EPC STORMWATER REVIEW COMMENTS ARE SHOWN IN ORANGE BOXES WITH BLACK TEXT

# PREDEVELOPEMENT GRADING FOR ROLLING HILLS RANCH NORTH AT MERIDIAN RANCH

TECH CONTRACTORS 11886 STAPLETON DRIVE FALCON, CO 80831 TELEPHONE: 719.495.7444 FAX: 719.495.2457		MERIDIAN RANCH	
PREDEVELOPMENT GRADING ROLLING HILLS RANCH NORTH ROUGH GRADING AND EROSION CONTROL PLAN COVER SHEET			
Drawn by	LOG	Checked by	TAK
Scale	AS SHOWN	Date	MARCH 2022
1 of 23		Revise to EGP222

PREDEVELOPMENT GRADING  
ROLLING HILLS RANCH NORTH  
ROUGH GRADING AND EROSION  
CONTROL PLAN  
GRADING INDEX SHEET

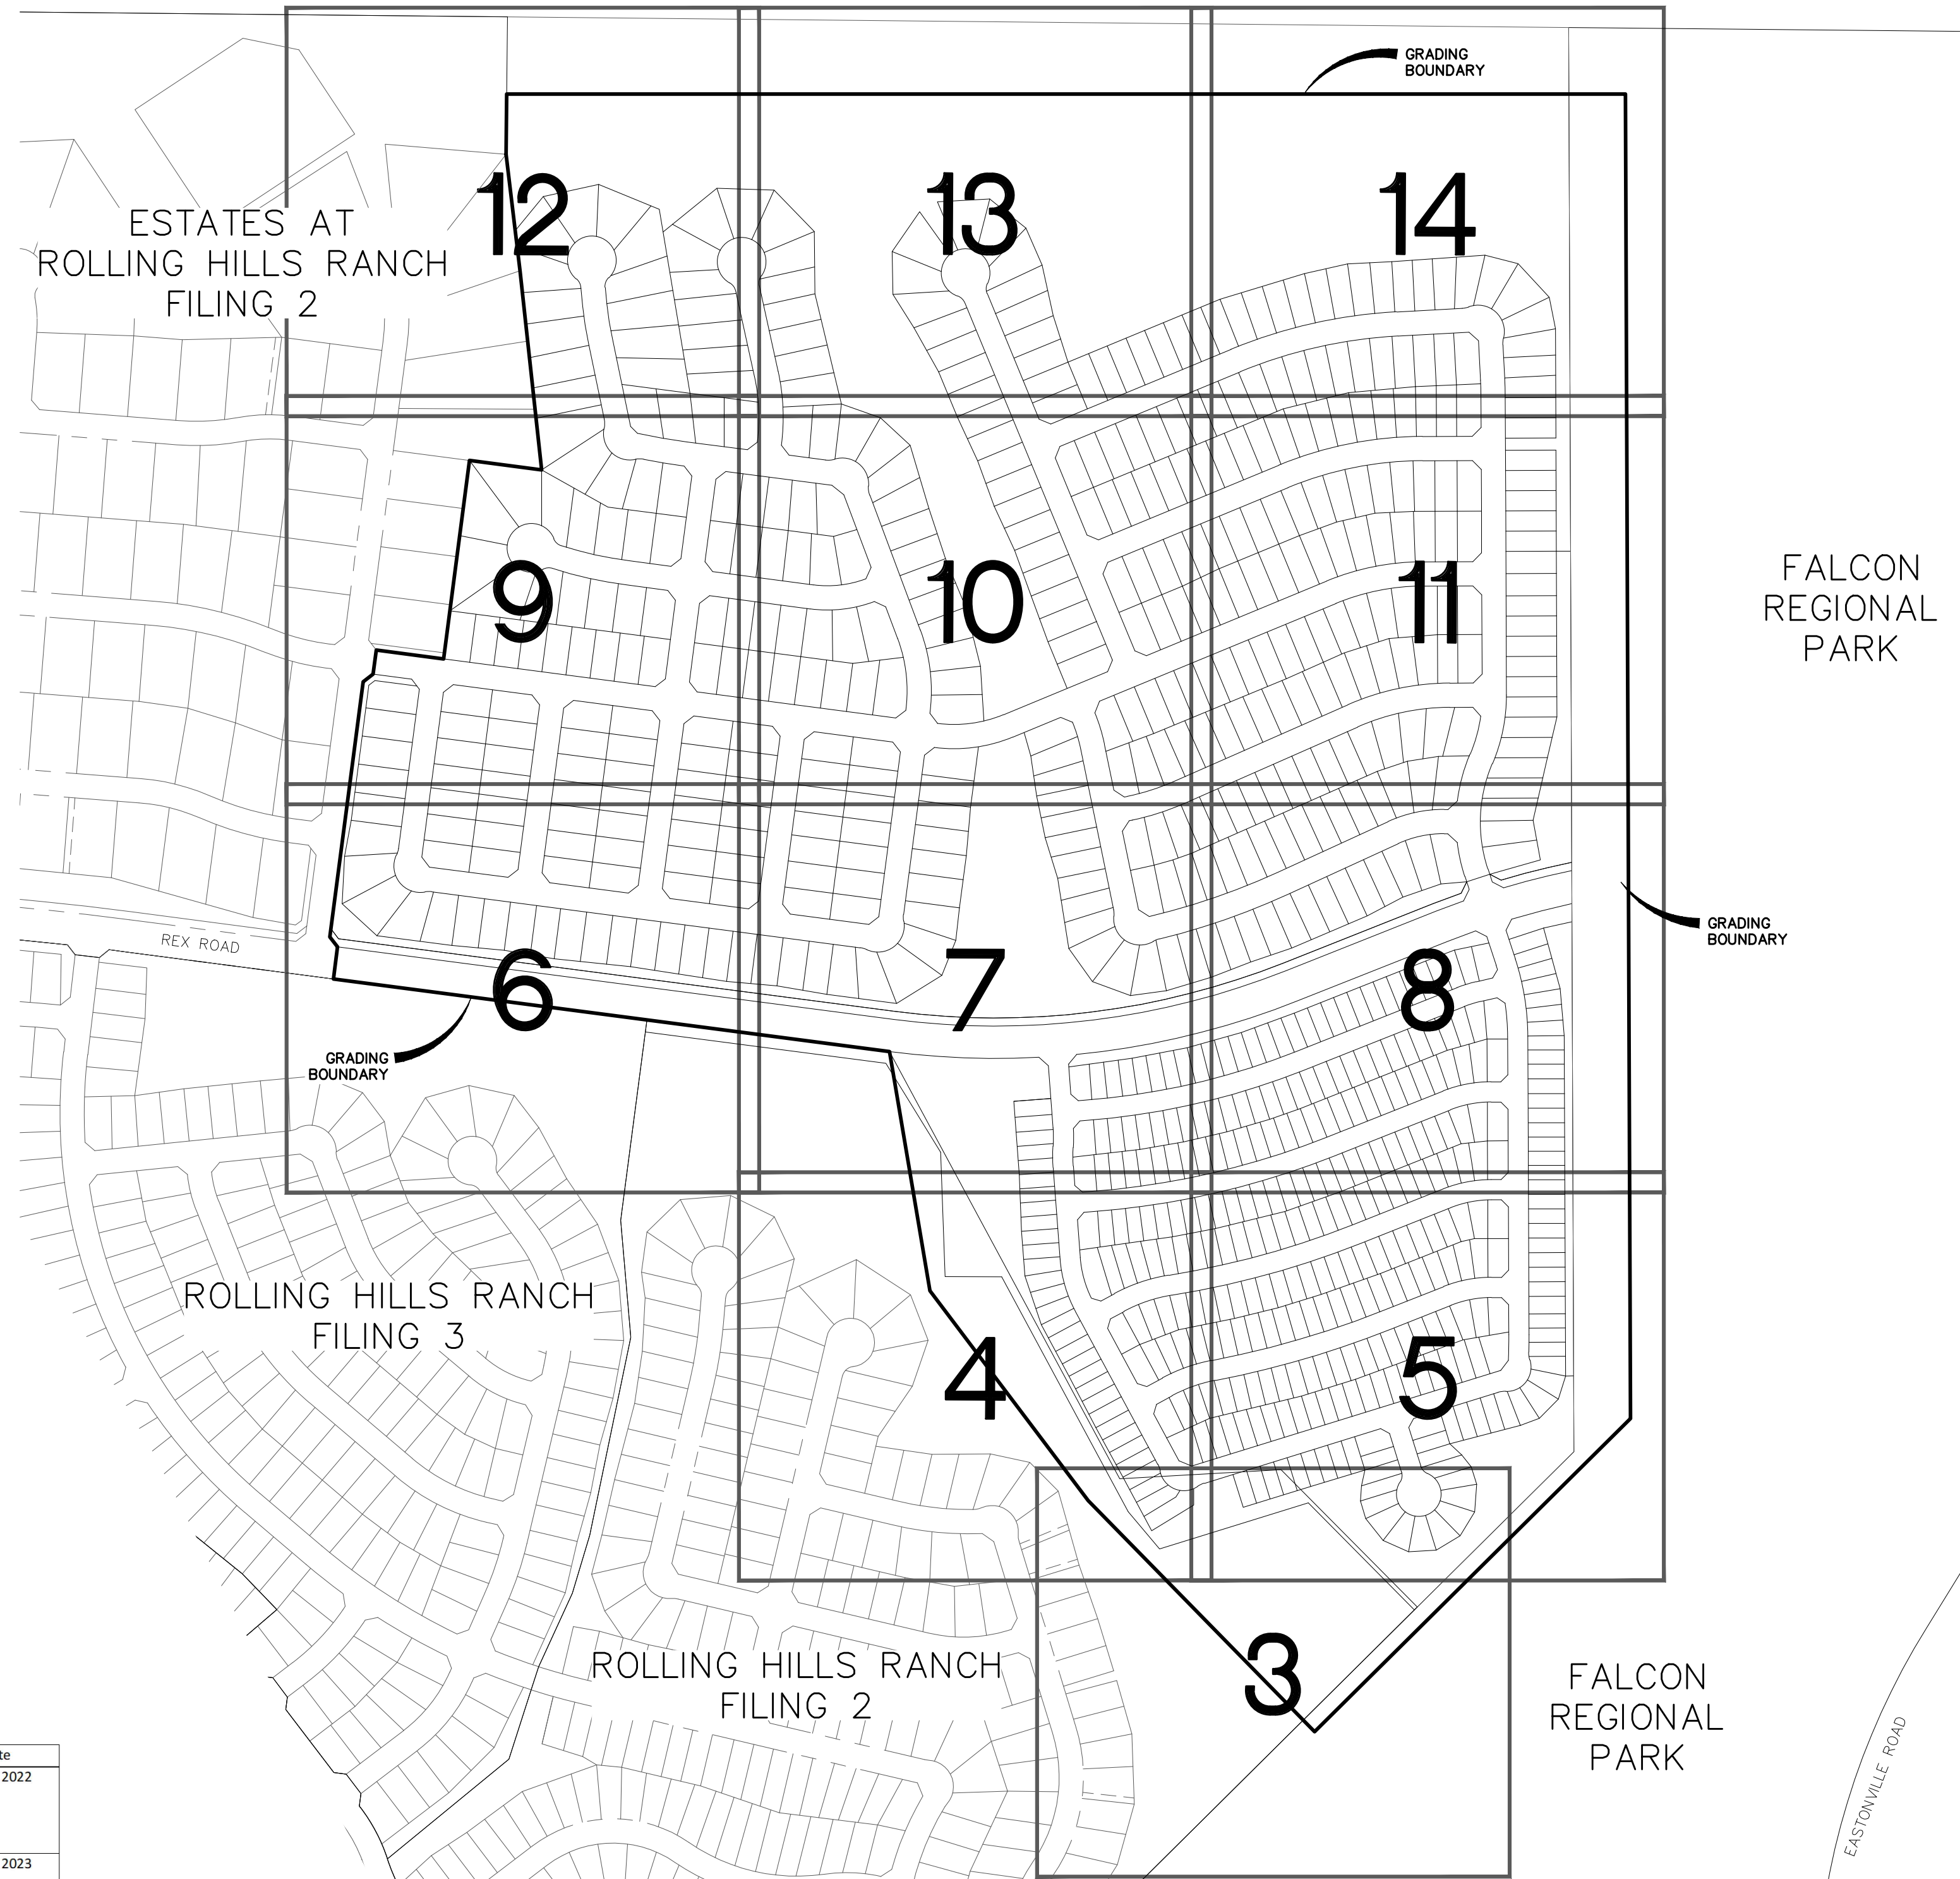
please include date of report

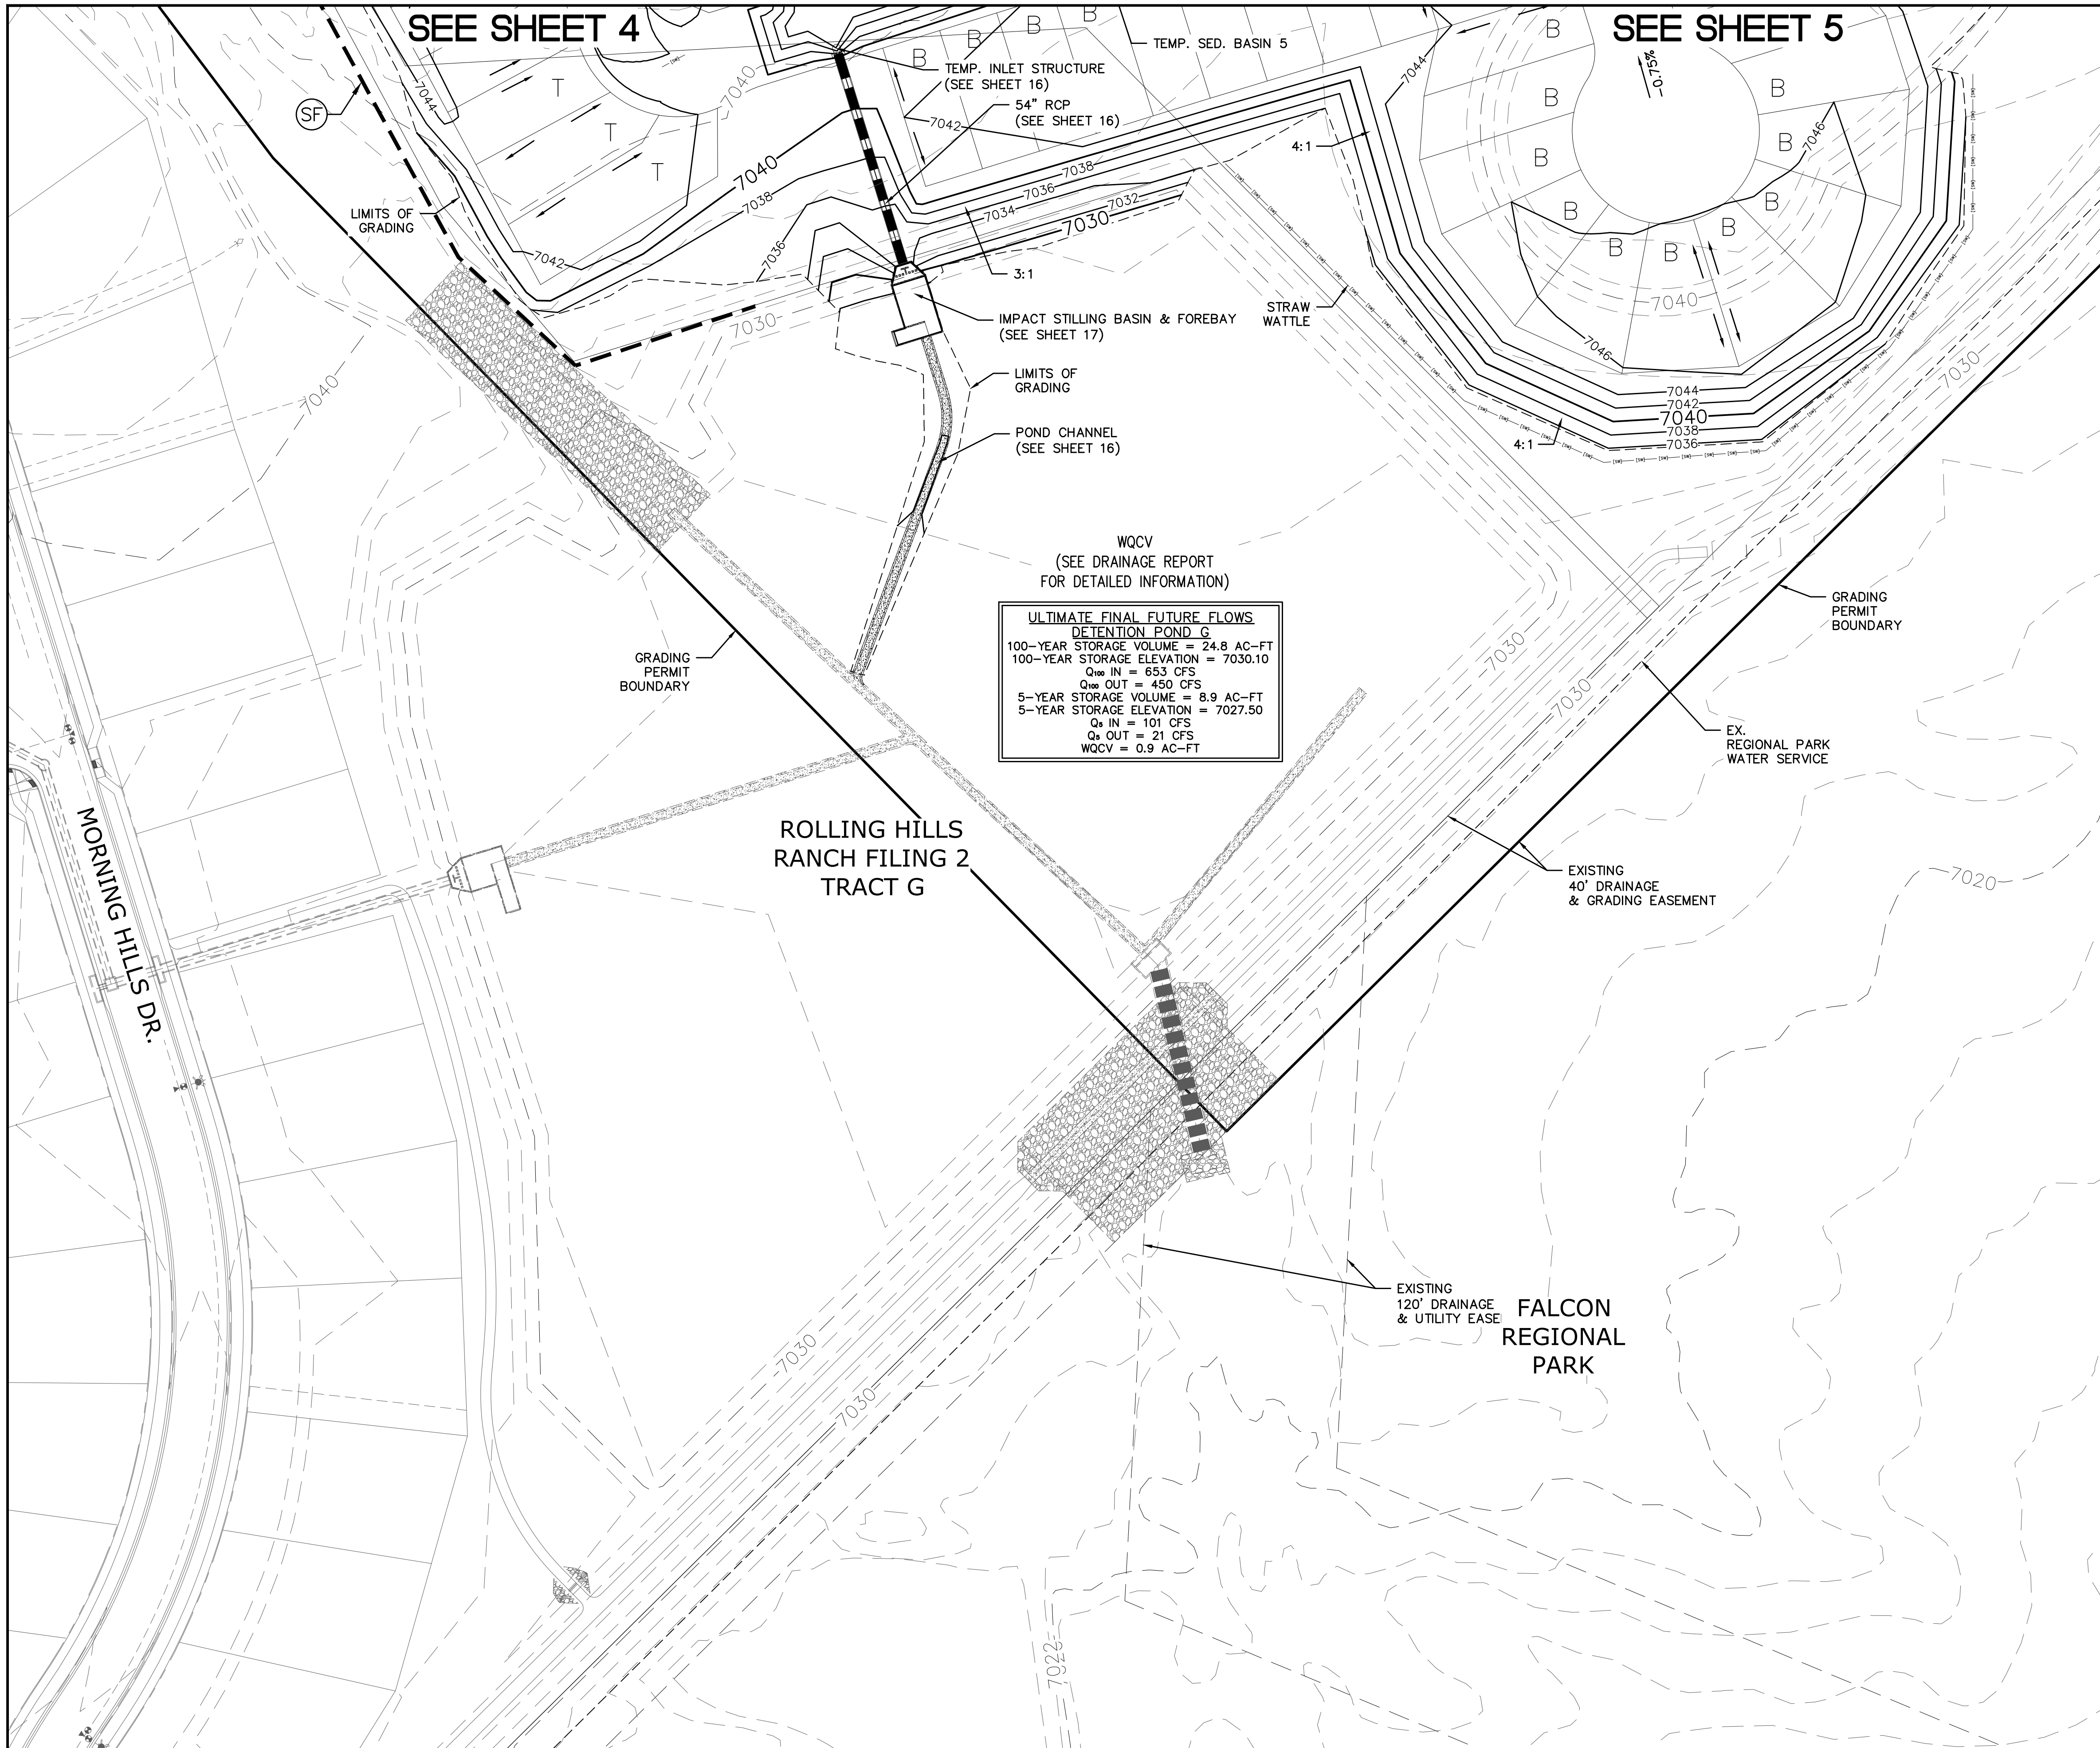
Please explain in the narrative why a 54" pipe and impact stilling basin is used. Staff assumes this is designed based on the full development of the subdivision and will remain after the temporary sediment pond is removed.

Please be aware that the construction/installation of this storm pipe system and the proposed water quality system is at the developers risk. Final approval of these will be based on the final plat's approved final drainage report and Construction drawings.
